# CITY OF ALBUQUERQUE

PLANNING DEPARTMENT – Development Review Services

**RE: Anderson Height Unit 4  
Drainage Report, Grading & Drainage Plan  
Engineer's Stamp Date 6-27-2014 (File: N08D006F)**

N-8/P-8 **1** **3**

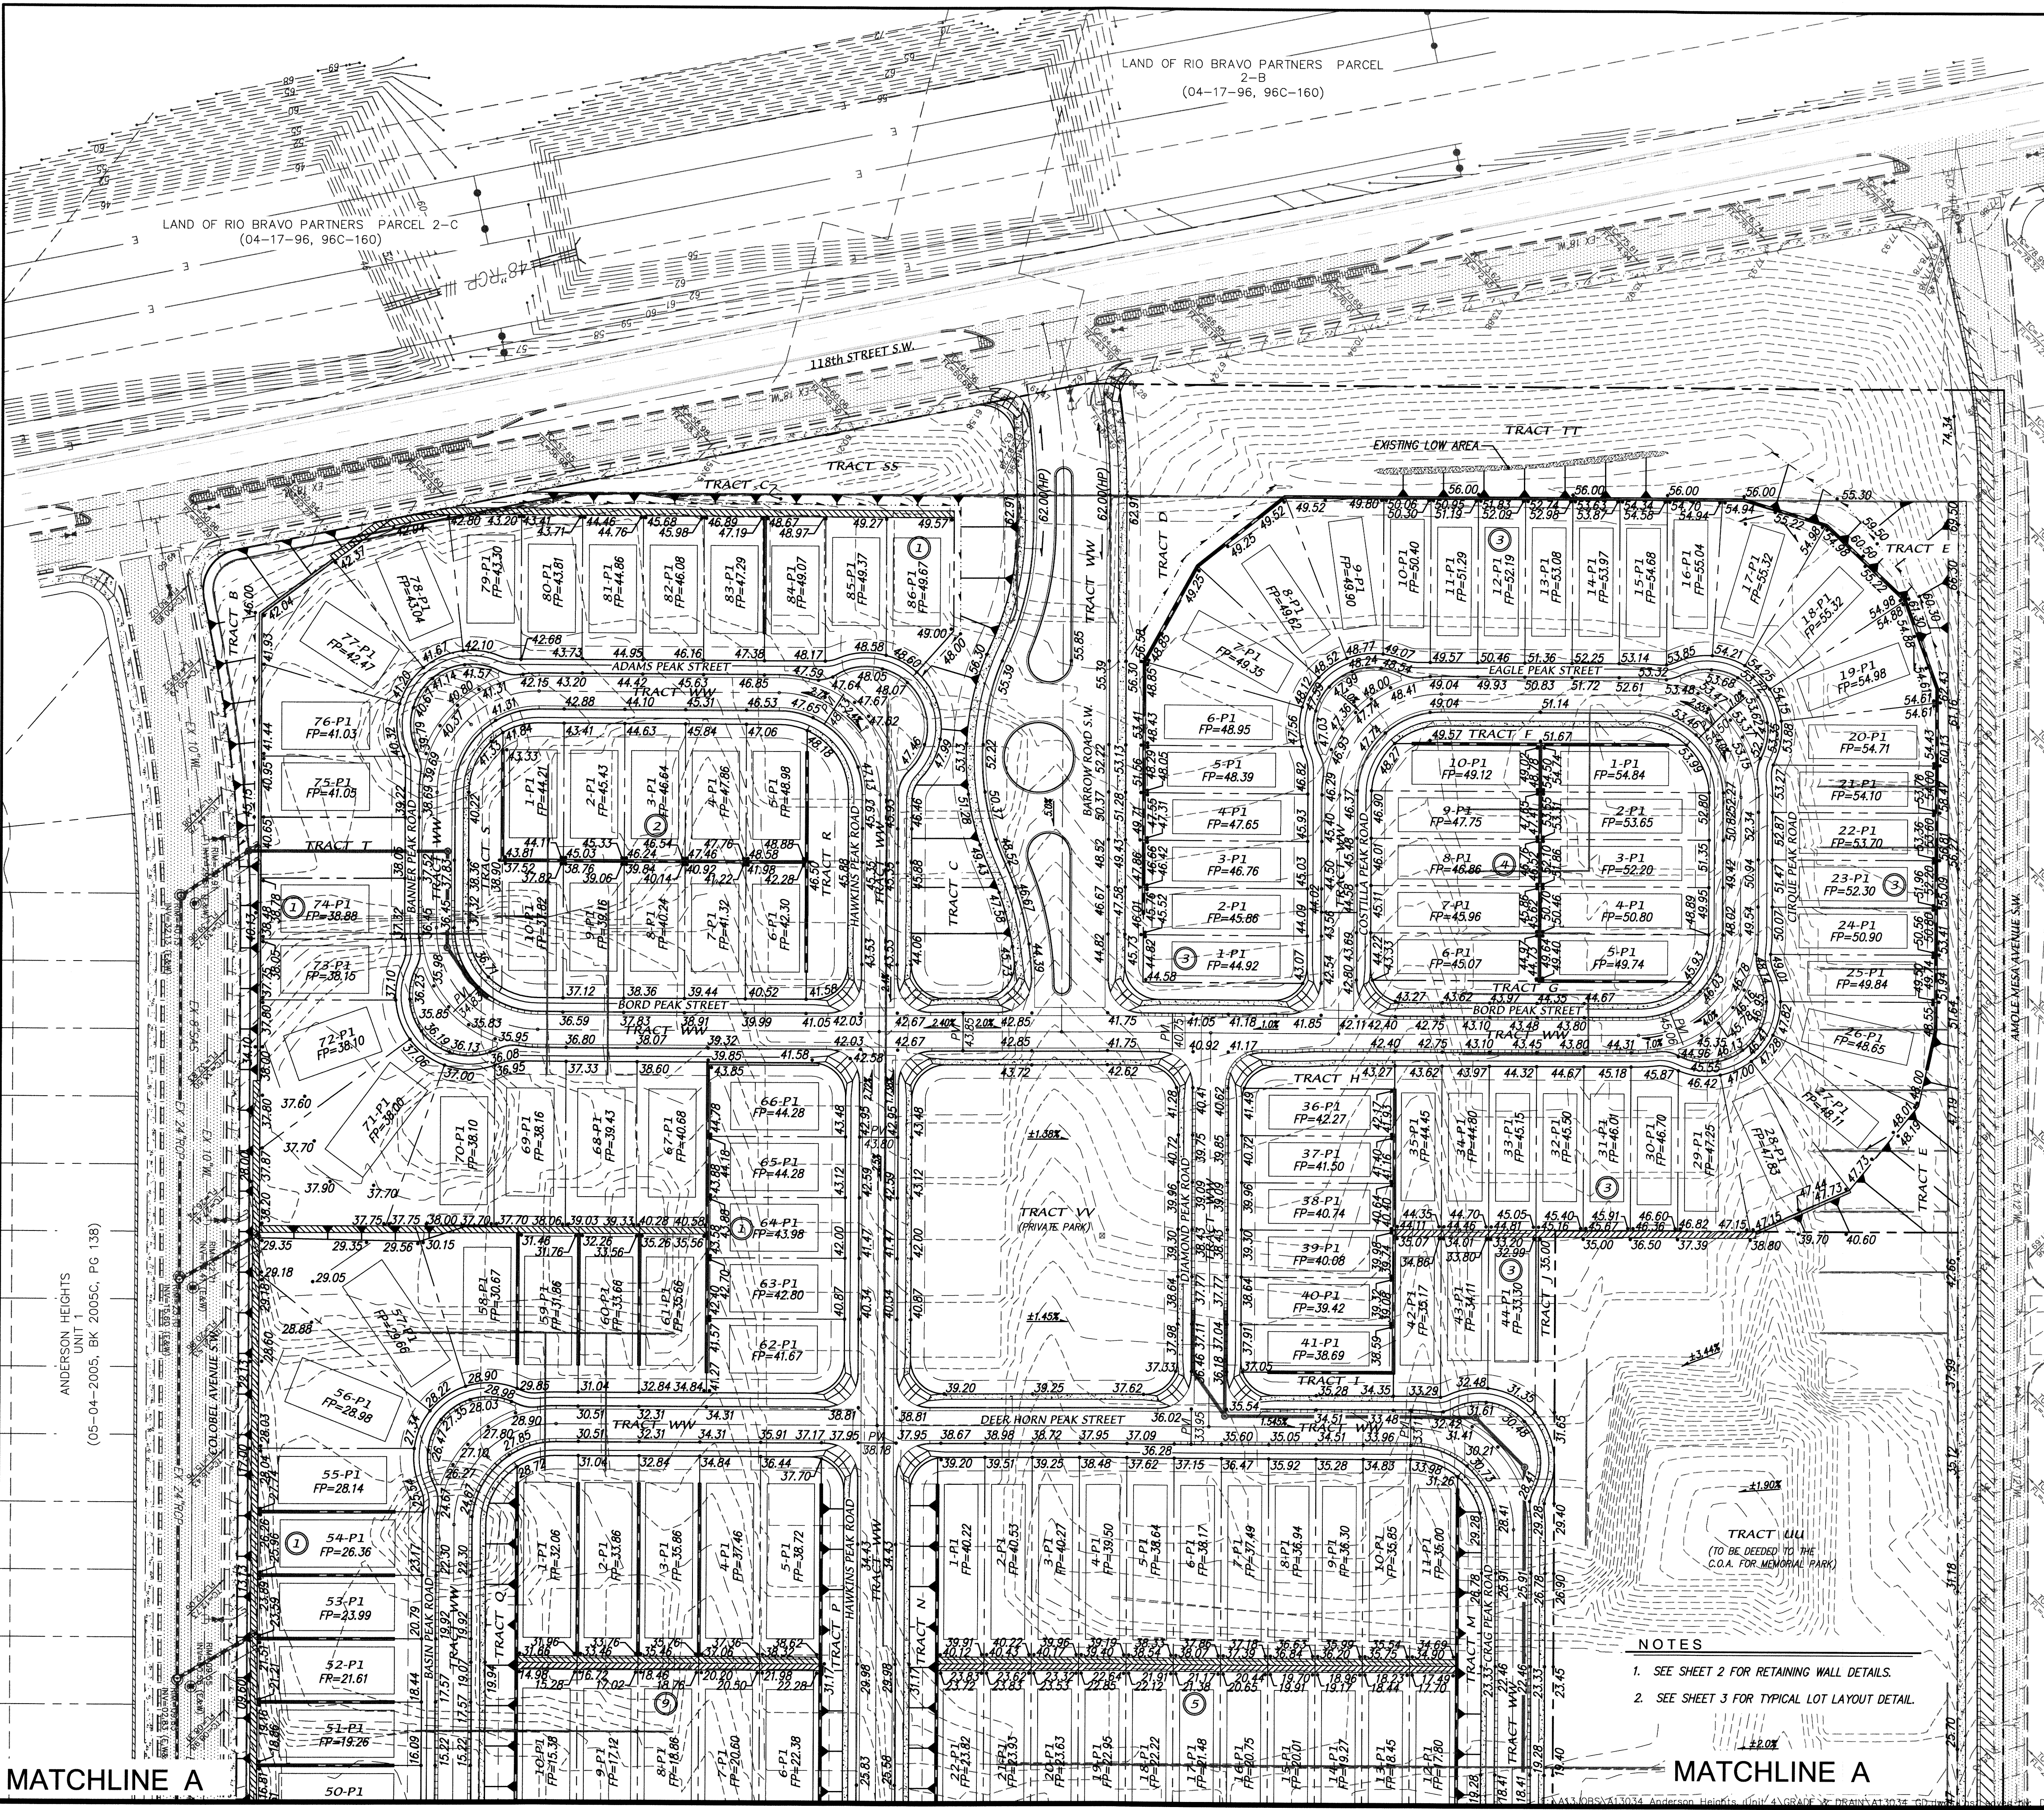
5. Per our conversation, I understand that the second retaining wall along the east property line which was installed for the interim conditions is to be removed in its entirety. However, there are concerns about the original retaining wall built with the Arrowwood subdivision, especially since a wall failure occurred sometime in the past. From my research, I found the following:

- a. The Arrowhead Hills G&D Plans for the development to the east, by Wilson and Company (enr's stamp date 10-12-05 and certified 9-19-06, Drainage file N9D008A) has a note: RETAINING WALL BY OTHERS COA 753981. It is unknown if the retaining wall was designed to retain the grades from the Anderson Heights Grading and Drainage Plan by Greg Krenik dated 4-14-05(Sht 6 & 7) and 4-27-05(Sht 9 ) or the existing grades. The existing grades were at or below the Arrowwood subdivision grades.

- b. We do not have in our records calculations showing that the original retaining wall was checked for additional pressures from the second retaining wall (as requested in a letter by Brad Bingham dated 12-4-2008), and may be overloaded at the present. It is our opinion that a structural engineer needs to evaluate the integrity

- of the original wall built with the Arrowwood Subdivision. If further information on the original wall is not obtained, a second wall will need to be designed and constructed parallel to the original wall. The footing will need to be deep enough (or further from the original wall) such that additional pressures are not placed on the original wall.

- c. The TW Elevation needs to be clarified. If typically the TW Elevation is the top of the structurally designed retaining wall, then the TW Elevation should average about 50' according to the as-built plans. The proposed plans show the average TW to be about 60'. The 10' difference leads me to believe that about 3.5' is a datum correction and the other 6.5' is a screen wall (or garden wall) built above the retaining wall. From my field visit, there is no visible joint (or change in block size) in the masonry where a surveyor would be able to determine the elevation of the top of the retaining wall.

6. Indicate that there are two walls along the east property line. Indicate that the existing second wall is to be removed.
  7. BW Elevations do not match up with the As-built BW elevations from the Arrowhead Hills G&D Plans nor the Anderson Heights Unit 9 G&D plan, stamped 9-10-07 in some areas. There is a 3.5' difference at one point. The existing contours along the wall do not match the TW elevations from Anderson Heights Unit 9 G&D plan stamped 9-10-07. For example, at 500' from the south property line the contour shows 57' along the wall, but the older plan says the TW is 53.55. As we have already discussed, the datum needs to be corrected. I am assuming the proposed contours are in the '88 datum. Are the existing contours in the '88 or the '29 datum? They should be the same datum. Further evidence that there are 2 different datums being used is at the west property line where some spot elevations do not match major existing contours.

8. Provide more elevation labels of the existing grade contours.
  9. A retaining wall is needed on west side of Lot 23-P1, along Emerald Peak Street.

10. What is the meaning of the hatching used between lots (ie. Between lots 58-P1 and 59-P1)? It is not on the legend. It seems to be a retaining wall in some cases (lots along Tract TT) but it is also used where a retaining wall would not be necessary (ie. Lots 1-P1 and 2-P1). Clearly indicate what walls are retaining and what walls are screen walls/ garden walls.

11. What do solid lines on either side of Tract U indicate? retaining walls?
  12. Water block should be raised at Barrow Road access from 118<sup>th</sup> Street.

TYPICAL RETAINING WALL DETAIL

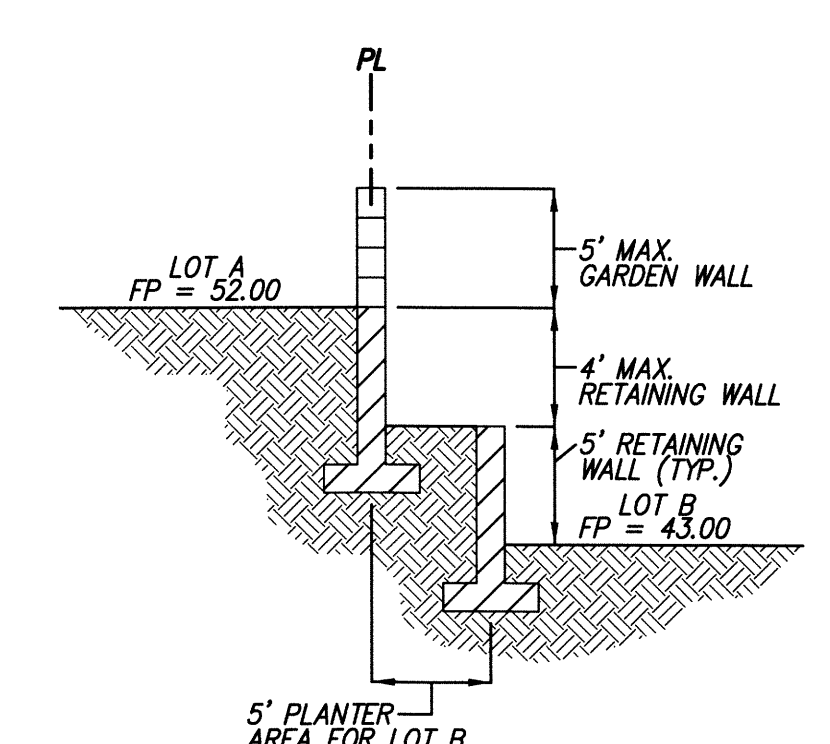
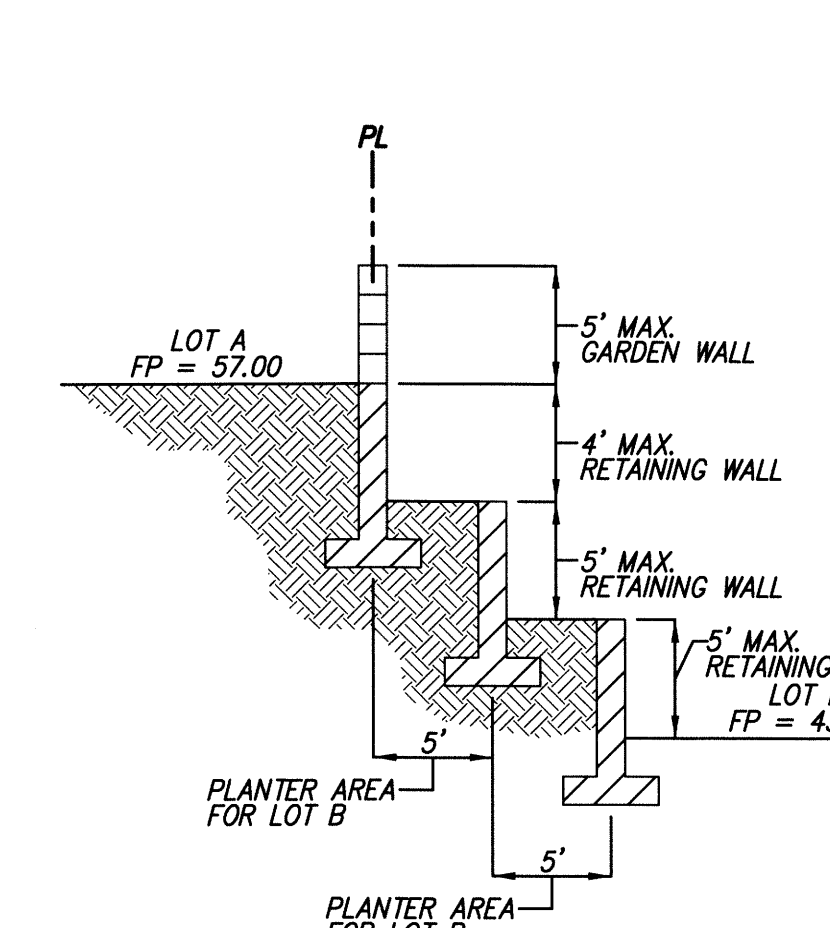
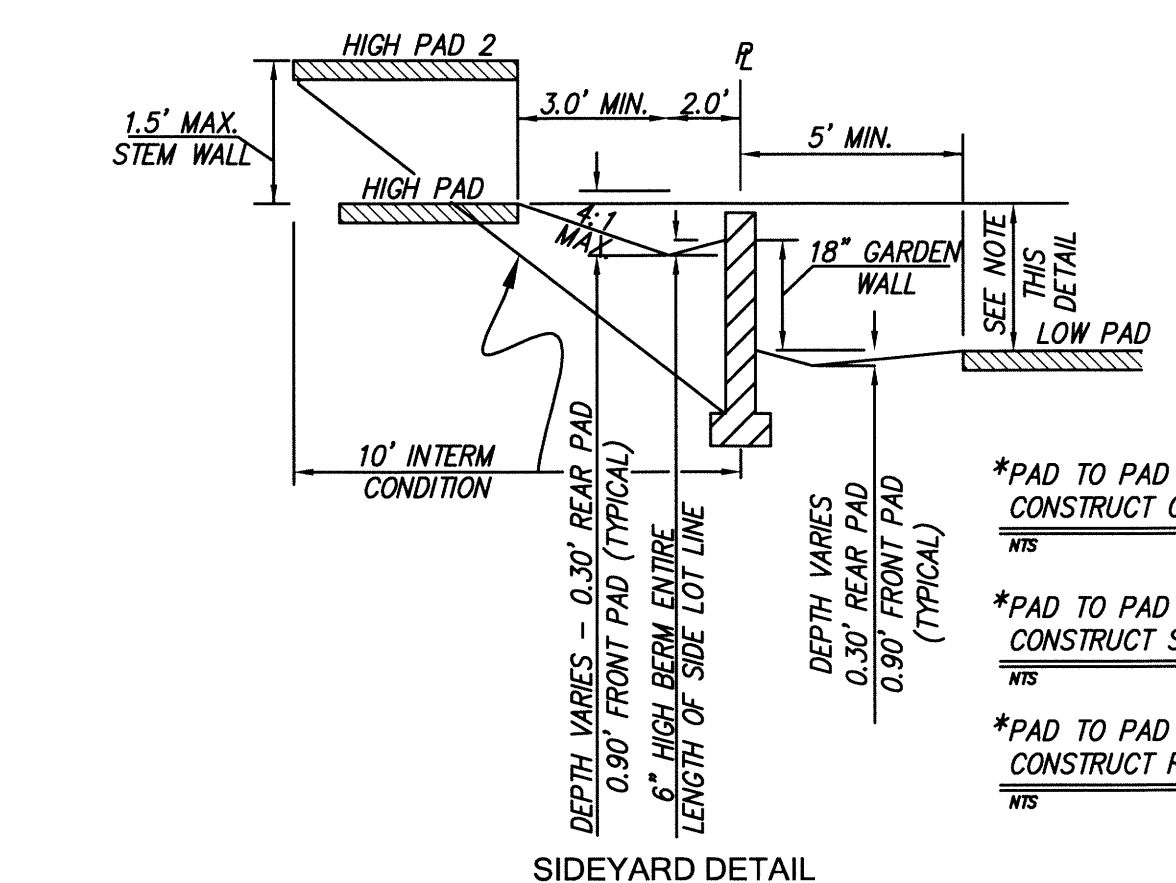
13. Show proposed contours at the memorial park (Tract UU), the private park (Tract VV) and Tracts Z, A, and B.
  14. The side yard detail on Sheet 2 has a High Pad and a High Pad 2. Where does this apply? What is the meaning of the "10' Interim Condition" note? It seems to be a detail carried from an older plan. Does it still apply?
